JIM WITT SUBDIVISION

DRAINAGE REPORT

June 5, 1996

RE: GRADING AND DRAINAGE PLAN FOR JIM WITT SUBDIVISION, (L23/D6B)
SUBMITTED FOR PRELIMINARY PLAT APPROVAL, ENGINEER'S STAMP DATED
5/17/96.

JIM WITT SUBDIVISION
PRELIMINARY GRADING AND DRAINAGE PLAN

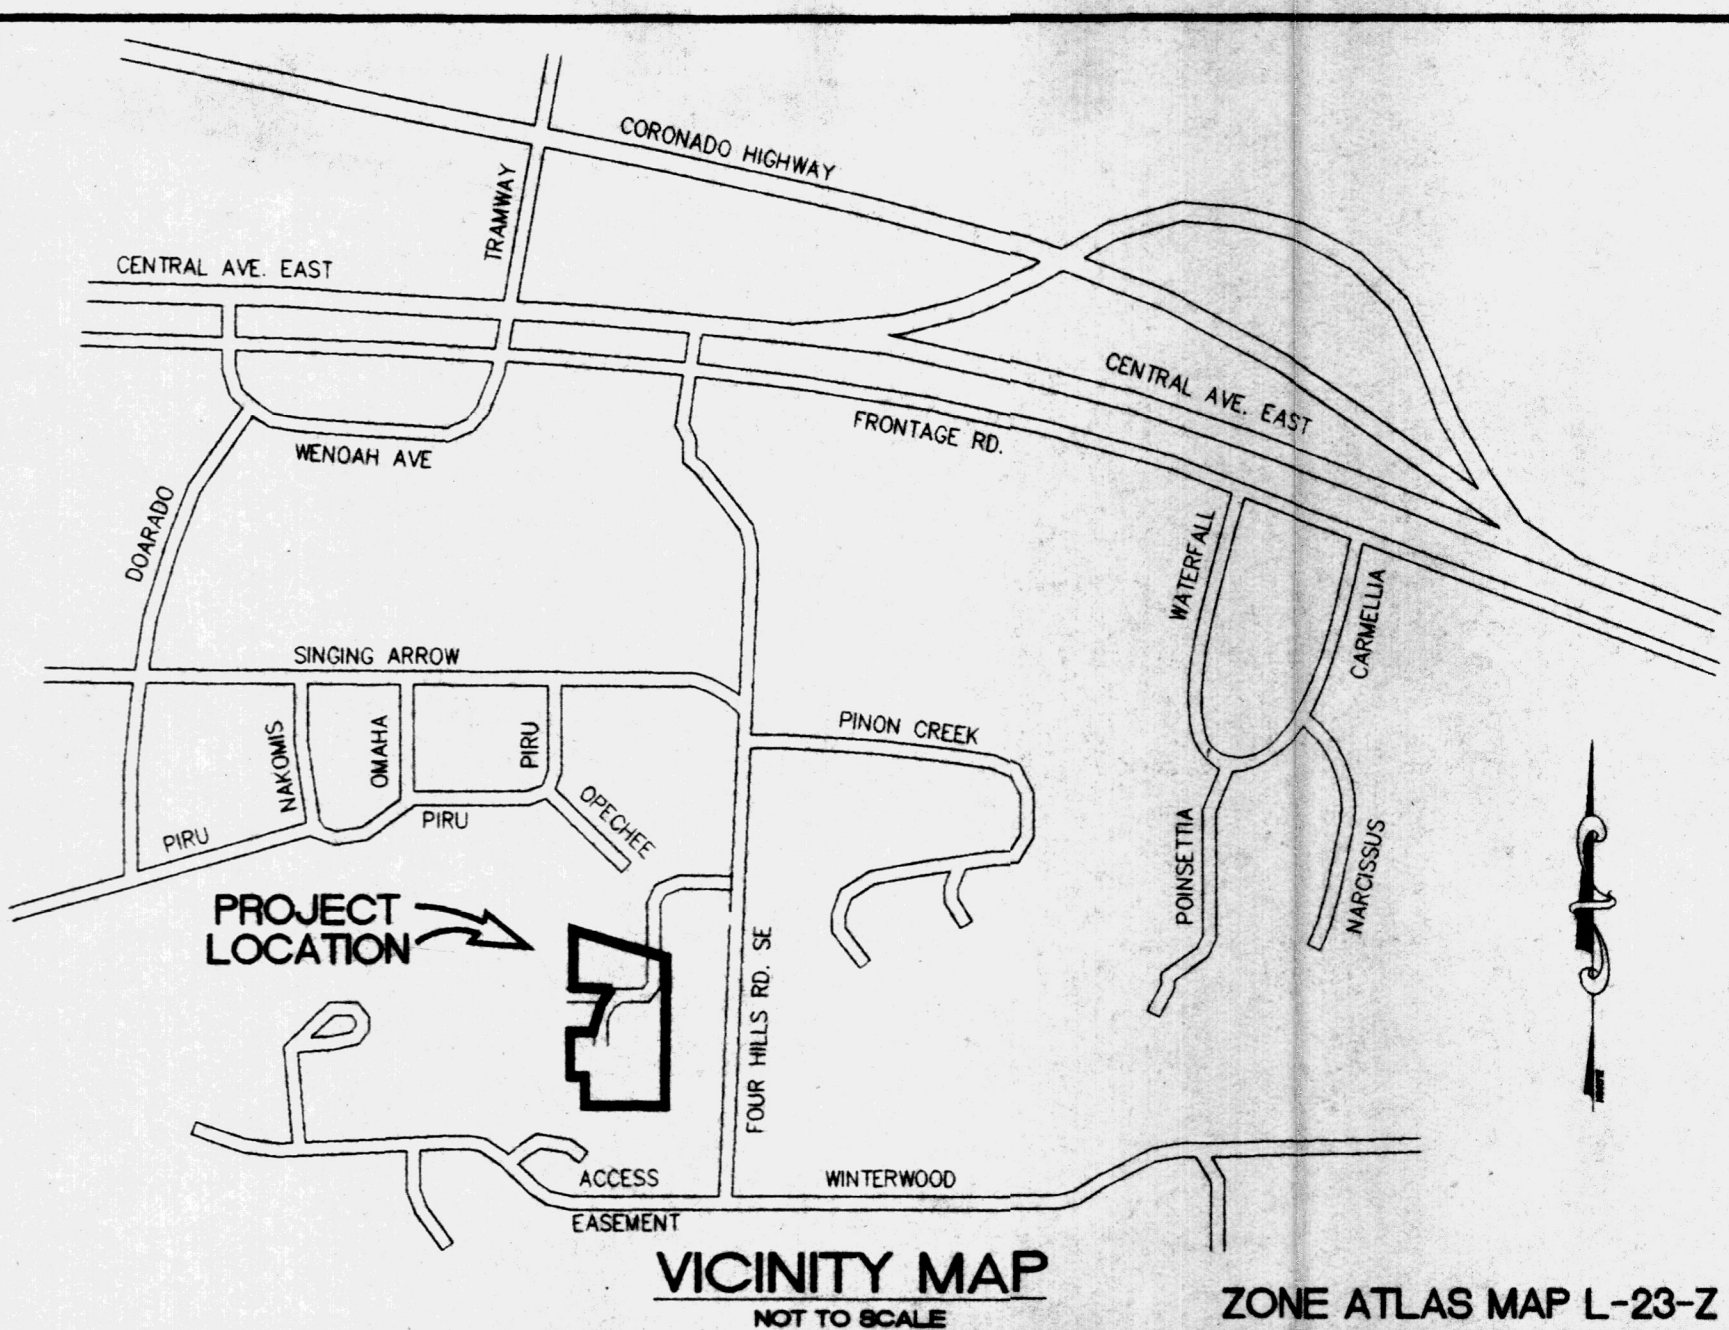
1. Please use the Zone Atlas to identify the site on the Vicinity Map. Also identify which portions are within the City and which are in the County. If this site has already been annexed into the City, please provide that information.

2. The plan must show the limits of the existing FEMA floodplain, as well as a copy of the FEMA Flood Insurance Rate Map with the site delineated on it.

3. A complete analysis of the Tijeras Arroyo must be included with the plan. If any development, including grading, is proposed within the floodplain, then an analysis of the proposed condition must also be included to show that grading will not adversely affect any adjacent properties. If you propose to change the existing floodplain, then a Letter of Map Revision must be obtained from FEMA.

4. The legend identifies water surface elevations for the arroyo. Please reference the study used. What Q was used? Please plot the HGL and EGL on the plan.

5. The plan indicates an existing easement for the bridge and floodway in the Tijeras Arroyo. What is this easement based on and who is the easement granted to? Is this easement adequate for the proposed development?

6. Do any off-site flows impact this site? If so, the basins must be identified and the flows quantified.
7. Although retention ponds are allowed in the County, they may only be used in the City on a temporary basis. It appears that with some modifications the ponds may become detention ponds which ultimately drain to the Tijeras Arroyo. Drainage swales or pipes between the ponds may be placed within private drainage easements.
8. Please calculate the erosion setback limit per AMAFCA's Sediment and Erosion Design Guide and plot this on the plan. Flood protection may be required for development within the erosion setback limit.
9. Typically finish floor elevations are set above the energy grade elevation plus freeboard.
